Your Ref: 23/00978/FUL
Our Ref: DWH/NA/A023/243

Project address: 17 Birley Street, Blackpool

We enclose a Variation of Condition application in relation to the above address. This application is to sub divide the windows on the 1st and 2nd floors of the front elevation and introduce an additional set of doors to the ground floor front elevation.

FRONT ELEVATION  
SCALE 1:50

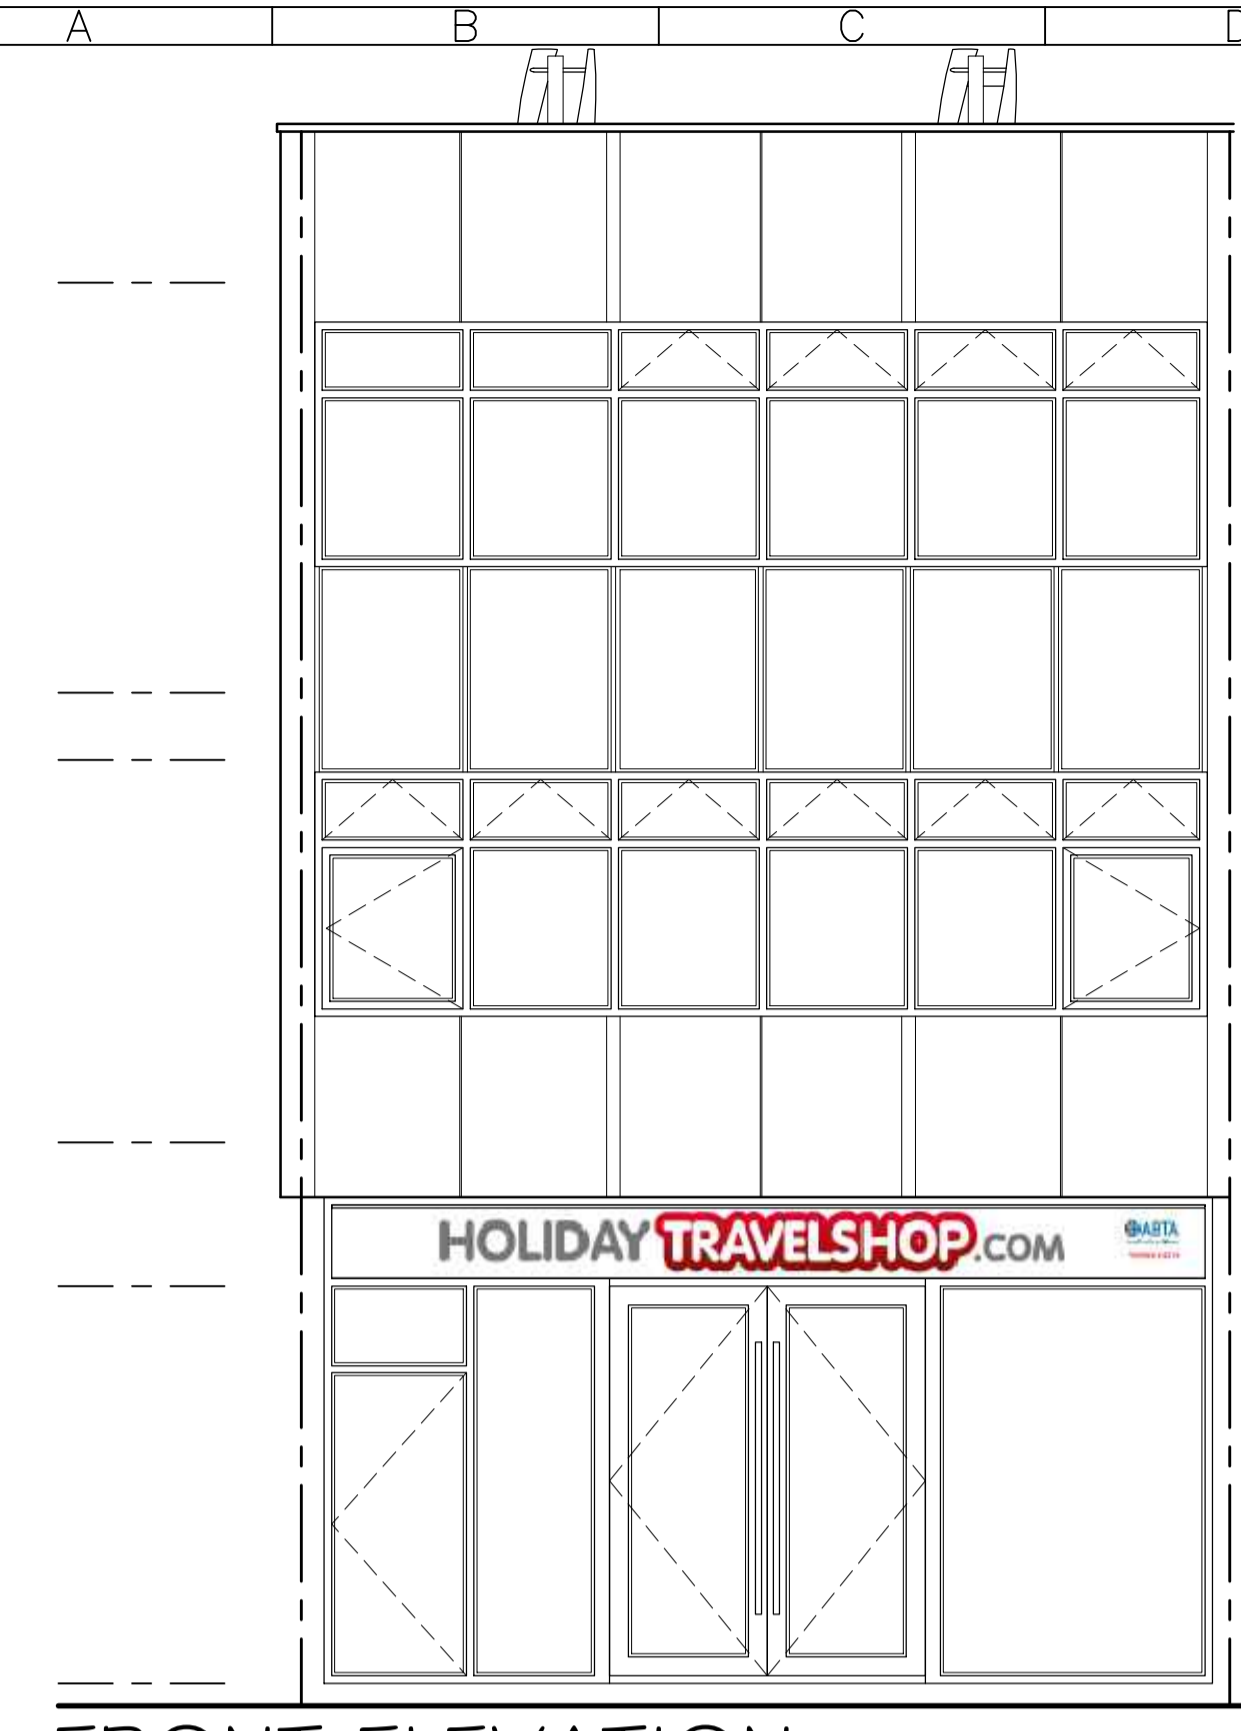
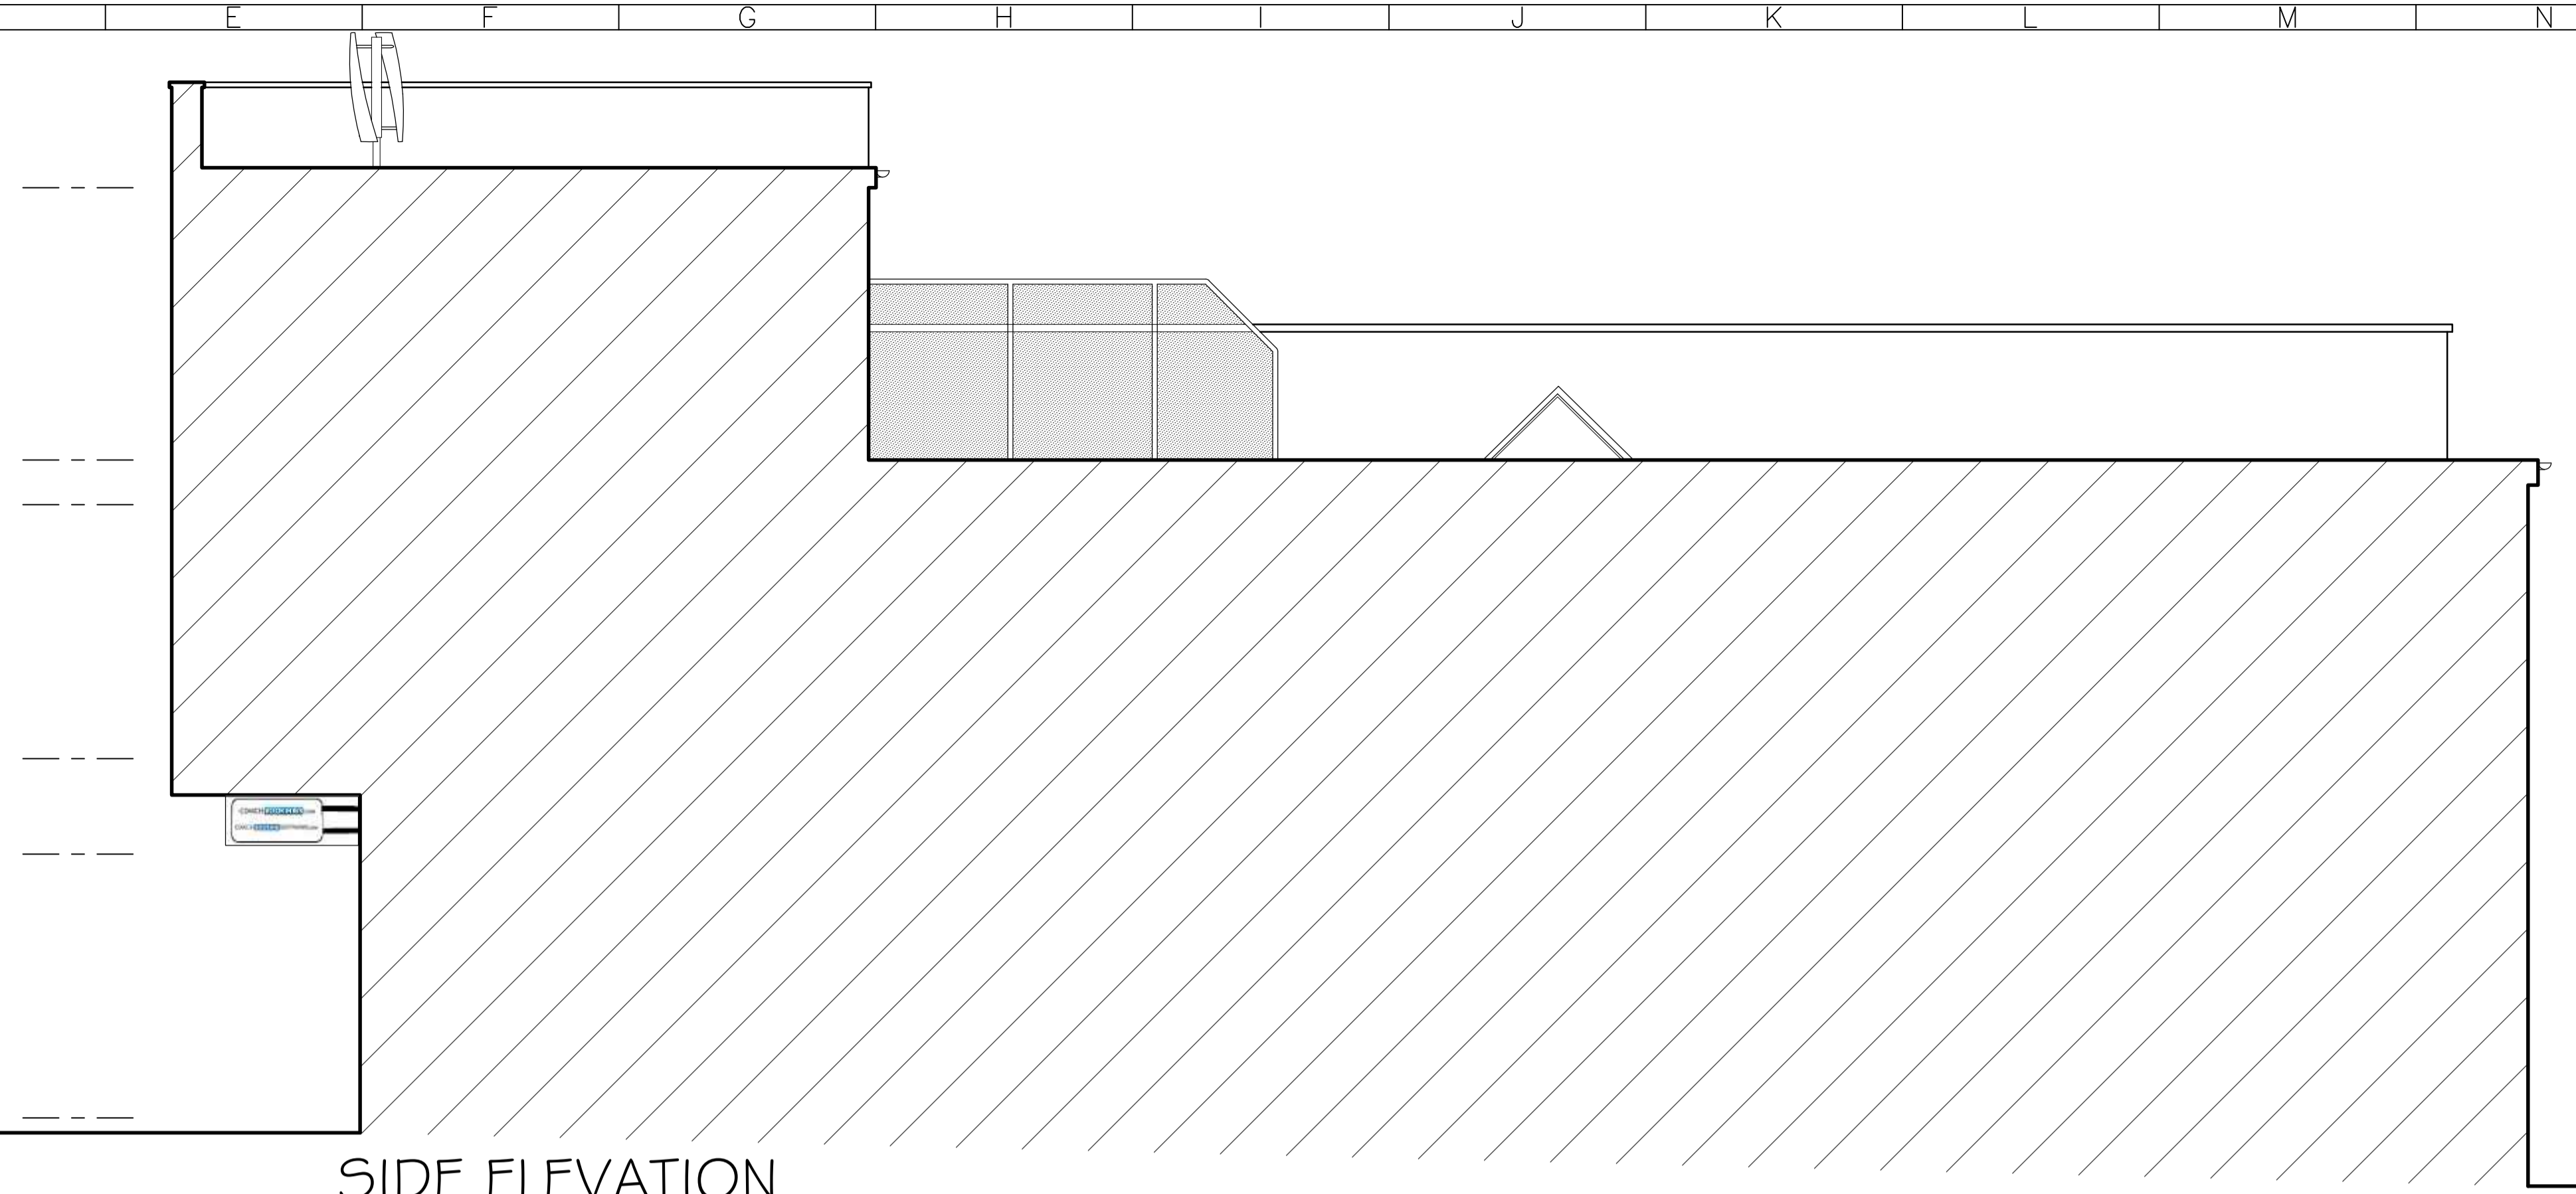
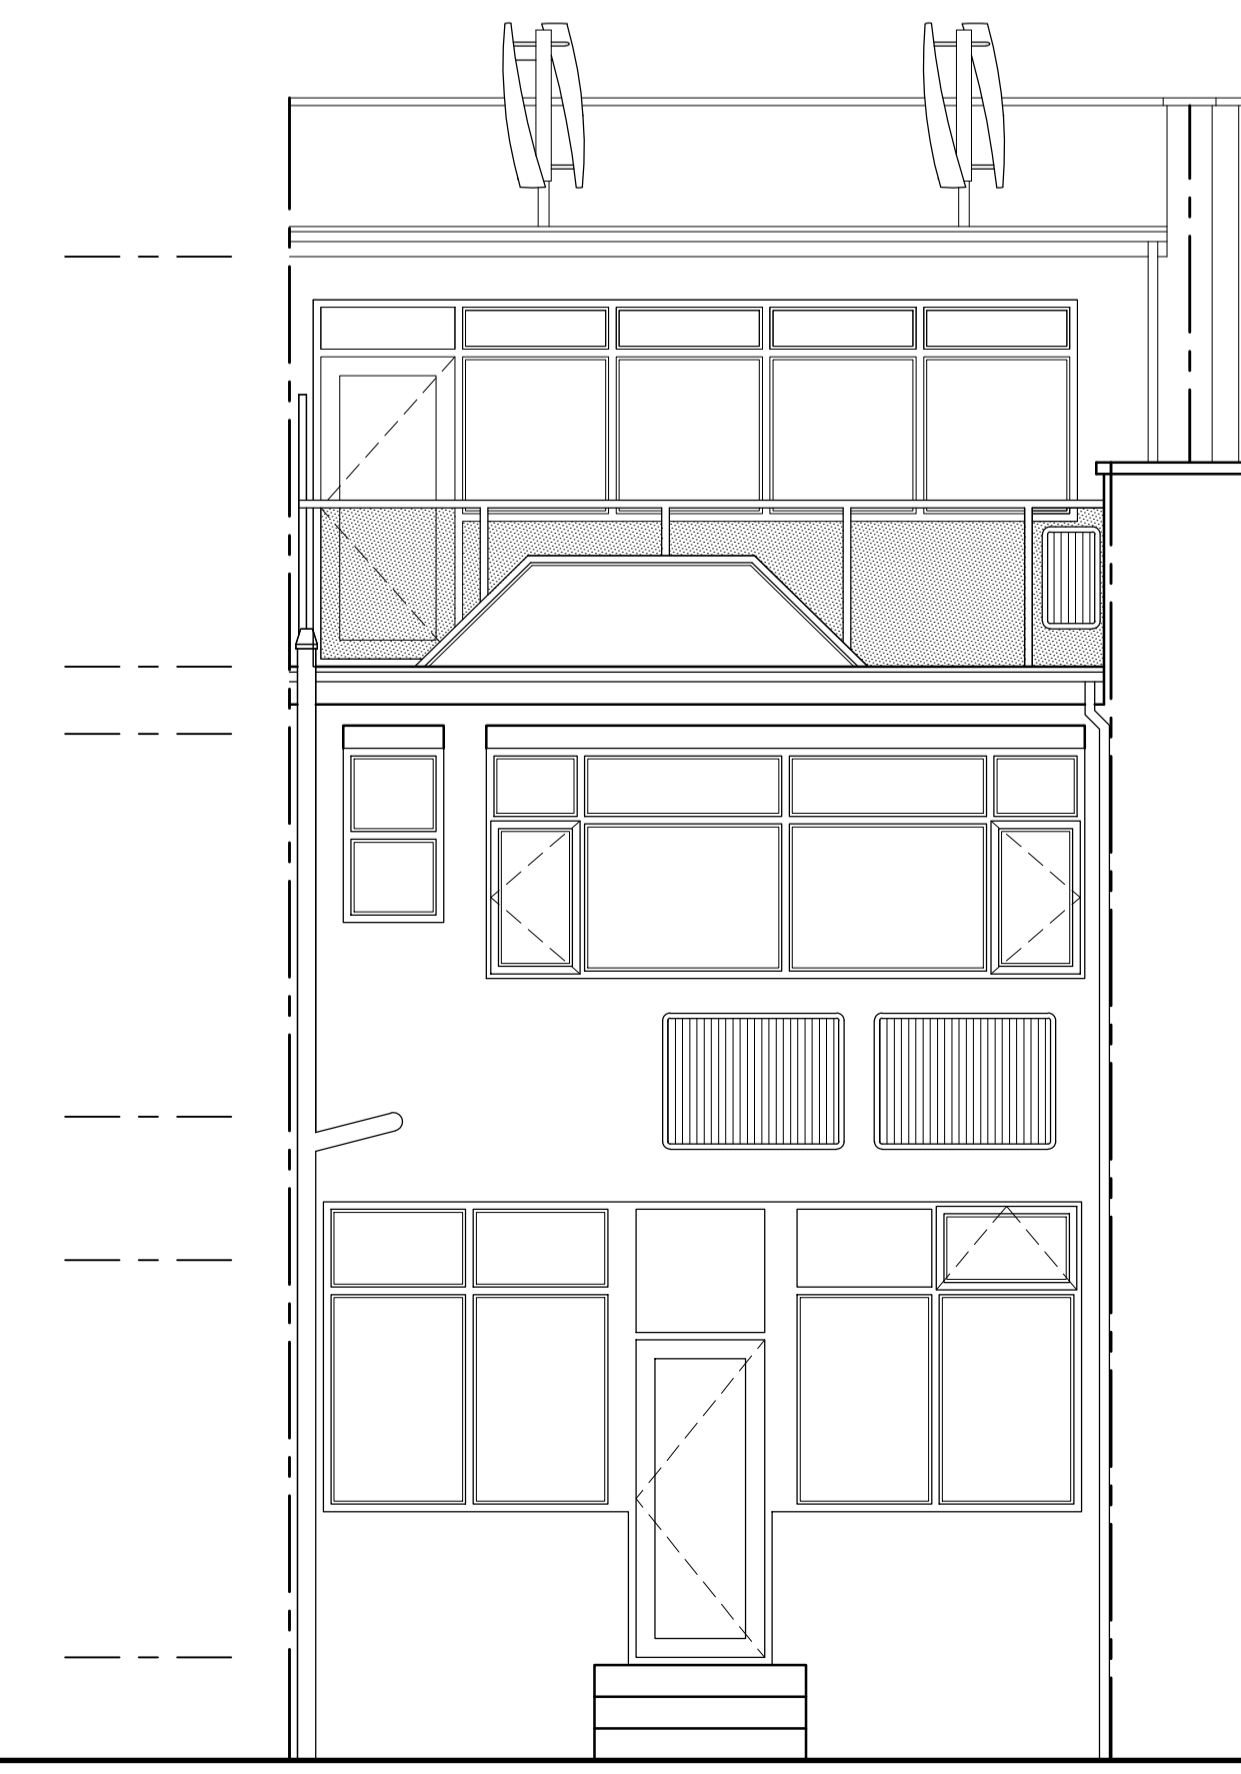
The replacement windows have been carefully designed to maintain the traditional aesthetics of the building, ensuring they blend in with the existing architecture. These proposed windows will also be more user-friendly.

The proposed installation of additional doors to the entrance of the building is to improve security and prevent unauthorised access during non-business hours. This proposal will prevent the ongoing issues of homeless individuals using the vestibule overnight, which can be intimidating and potentially dangerous for staff arriving to work.

As the building is located in a Conservation Area, planning policy will not allow the addition of shutters. However, installing an extra set of doors will ensure that the vestibule will be inaccessible to homeless individuals during non-business hours, ensuring the safety and peace of mind of the staff and passersby. The added security will also protect the building and its contents from further vandalism or theft. Additionally, double entrance doors can help regulate temperature within the retail space by reducing drafts and air exchange. This can prevent cold air from entering during the winter months and hot air during the summer, minimizing the need for heating or cooling systems to work harder to maintain desired temperatures.
